CITY OF ALBUQUERQUE  
ADMINISTRATIVE APPROVAL (AA)- SITE DEV PLAN AMENDMENT  
ROUTING & REVIEW SHEET

APPLICATION #: 14AA-10038	PROJECT #: <del>100</del> 1010075
PROJECT NAME: Frito Lay - Renaissance	
APPLICANT or AGENT: Tierra West - John Nrslei	
PHONE # and E-MAIL: 858-3100	
ZONE ATLAS PAGE: F-16	
ADMINISTRATIVE APPROVAL (AA) for:	<input type="checkbox"/> EPC CASE <input checked="" type="checkbox"/> DRB CASE

**RE: ADMINISTRATIVE AMENDMENT  
TR 9 AIA PLAT OF TRS 9AIA & 9A1B RENNAISSANCE CENTER  
ZONE MAP F-16**

**Project # 1010075      Administrative Amendment Request**

NORTH ELEVATION
SCALE: 1/4" = 1'-0"

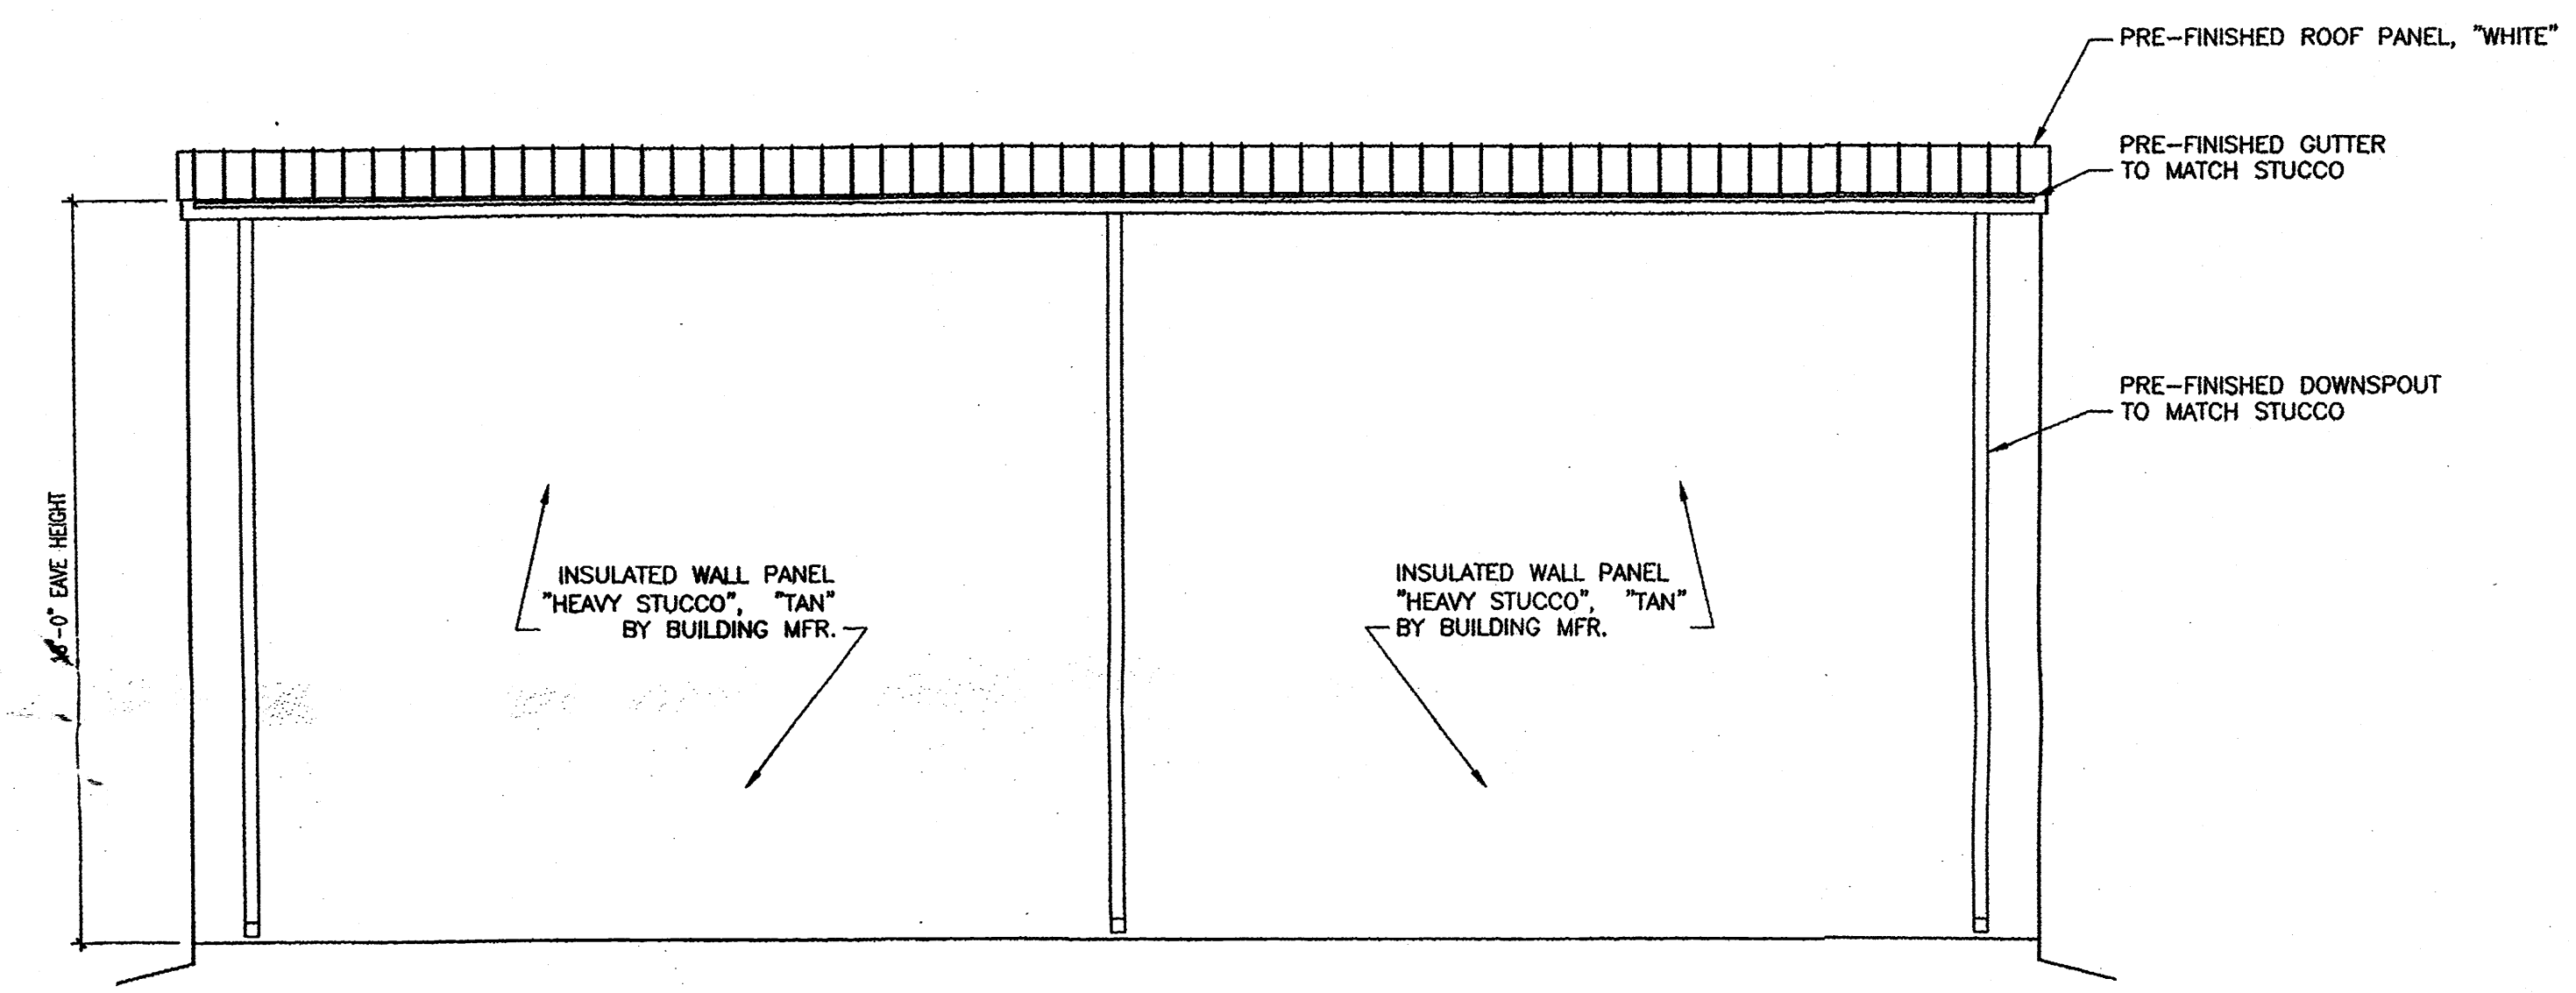
CURRENT PLANNING	DATE RECEIVED: 5-2-14
APPLICATION COMPLETE:	DATE: 5-2-14
APPLICATION INCOMPLETE:	DATE:
ROUTING NEEDED:	<input type="checkbox"/> YES <input checked="" type="checkbox"/> NO
COMMENTS:	
<p>① complete - may want more detail on elevations (eral using Renaissance master plan standards) (cl)</p> <p>② site looks non-compliant with existing approved site plan - esp landscaping - see aerial photo.</p>

ENGINEER'S SEAL	FRITO LAY	DRAWN BY: JDN
	SITE PLAN	DATE: 05-11-98
	TERRA WEST, LLC 4421 McLEOD ROAD, N.E., SUITE D ALBUQUERQUE, NEW MEXICO 87109 (505)883-7592	9844SP.DWG
RDNALD R. BOHANNAN P.E. #7868		SHEET # 1 OF 4
		JOB # 980044

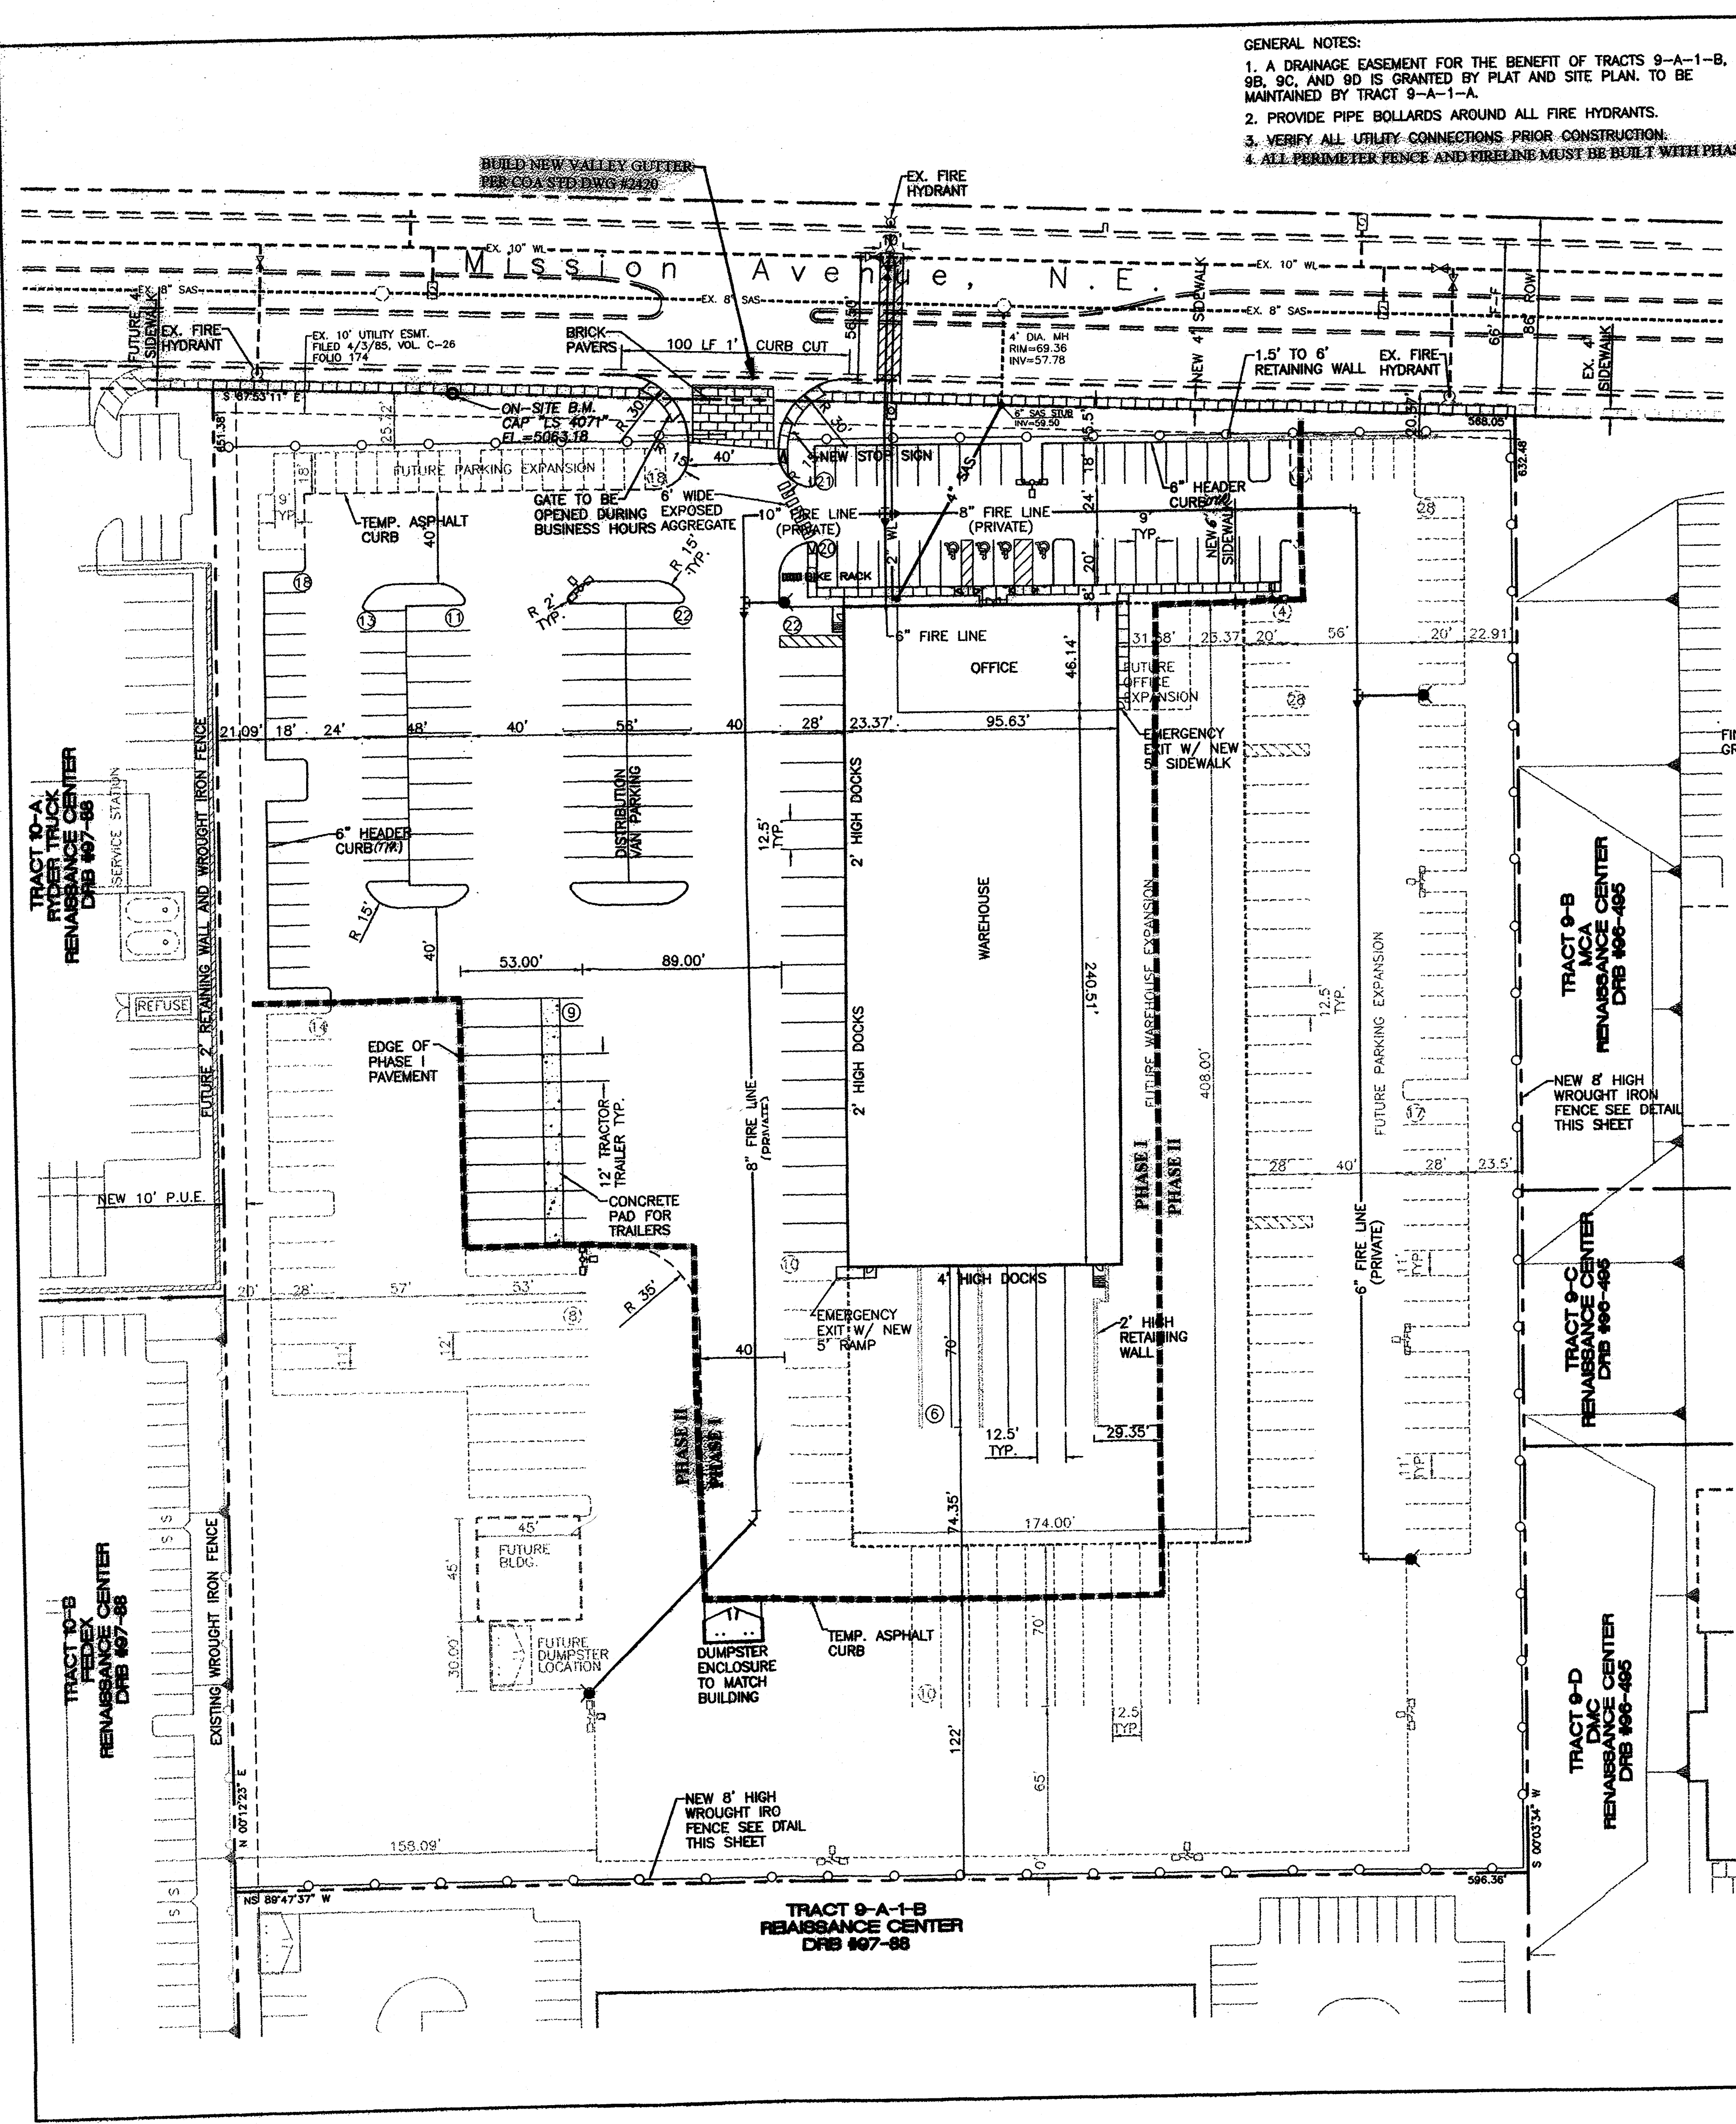
- ✓ • Are you replacing the future 45'x45' building or is it being removed from site? This building does replace the "Future 45'x45' building that is shown on the plans.
- The Proposed building is in the middle of a curb which may be needed for truck movement. Please provide more detail or move the building back. The building is being placed in an area of a very wide drive aisle next to some parking spaces. The curb is a temporary asphalt curb that was always designed to be removed to expand the parking lot.
- The building is being proposed in the "Future" parking area. Traffic circulation needs to be redesigned around the proposed building to reflect the new layout. The future parking spaces behind the building may still be used and accessed by the future expansion of the parking lot. There is a drive aisle east of the building that will allow the parking spaces to be used.

Attached is an exhibit showing how the Frito Lay circulation would work with ultimate build out. The building is being placed in an area of extra pavement. The trucks only need a 40 foot drive aisle to reach the back of the store for loading. The 89 feet width is extra area for parking. The two spaces behind the building are accessed by a 57 foot drive aisle.
